Application no: 21/01746/DISC

Location: Land And Former Buildings UH11 442 465 466 467 468 470 471 481 492
493 529 593 596 Dow Street Heyford Park

The Applicant for the above application requires the discharge of condition 7 (Travel Information Pack) of 16/00627/REM (Phase 5)

Key issues:

Heyford Park Site Layout

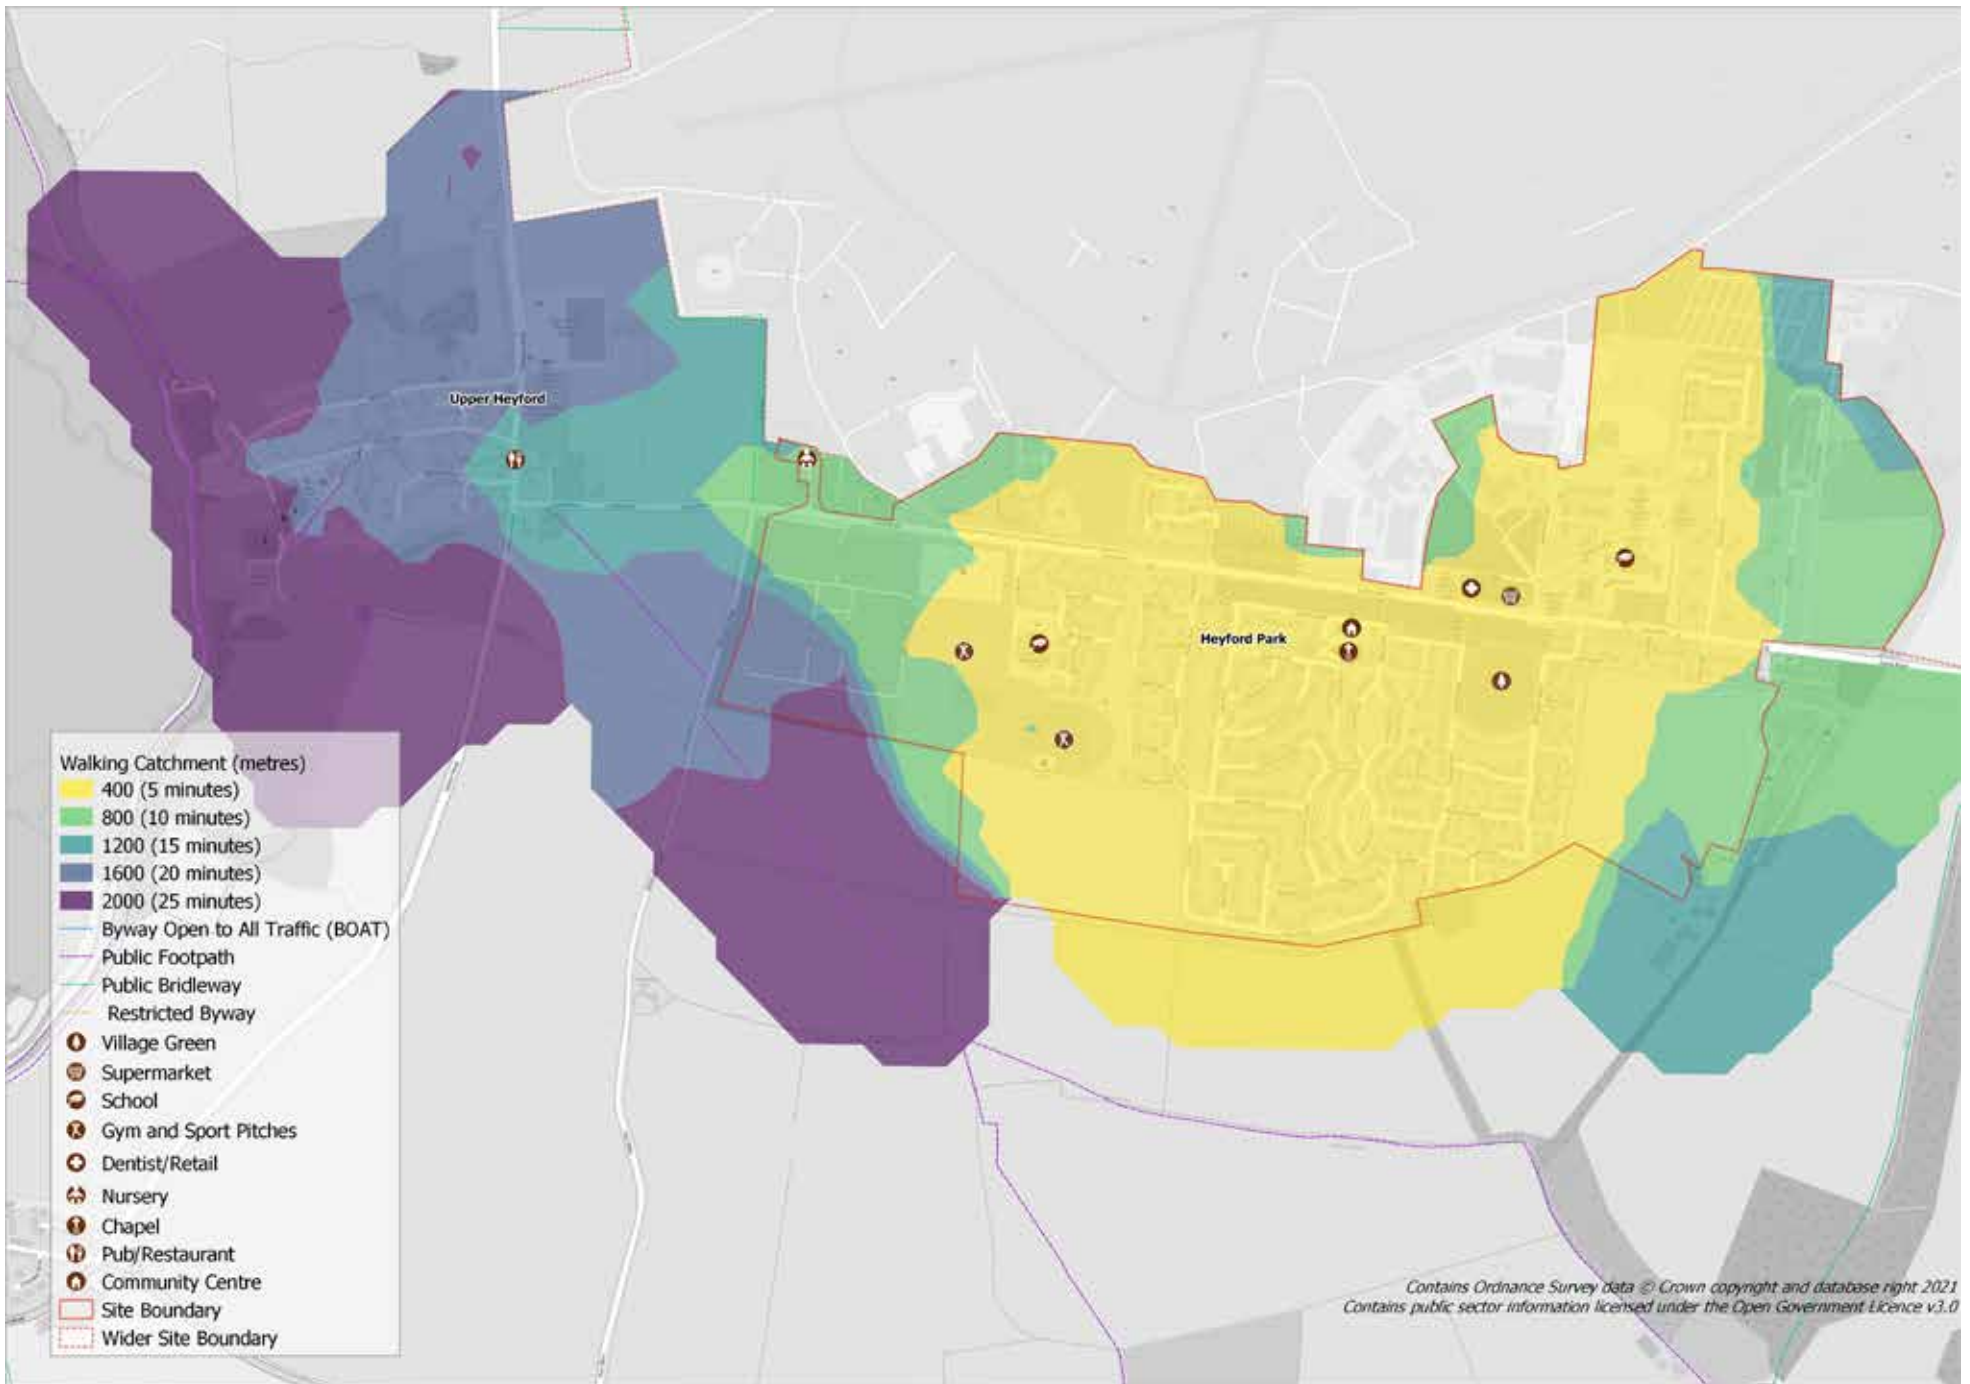
- Add the location of the site onto the site layout map. Make this clear.
- Section 2 – provide email addresses for the useful contacts.
- Section 3 – provide details on cycle parking.
- Section 5:
 - Detail key destinations and journey times.
 - Add a link to the Railcards [website](#).
- Add a section on EV charging.
 - Include [Park & Charge Oxfordshire](#).
- Add a section for local taxi companies.
- Add a section detailing supermarket delivery options.
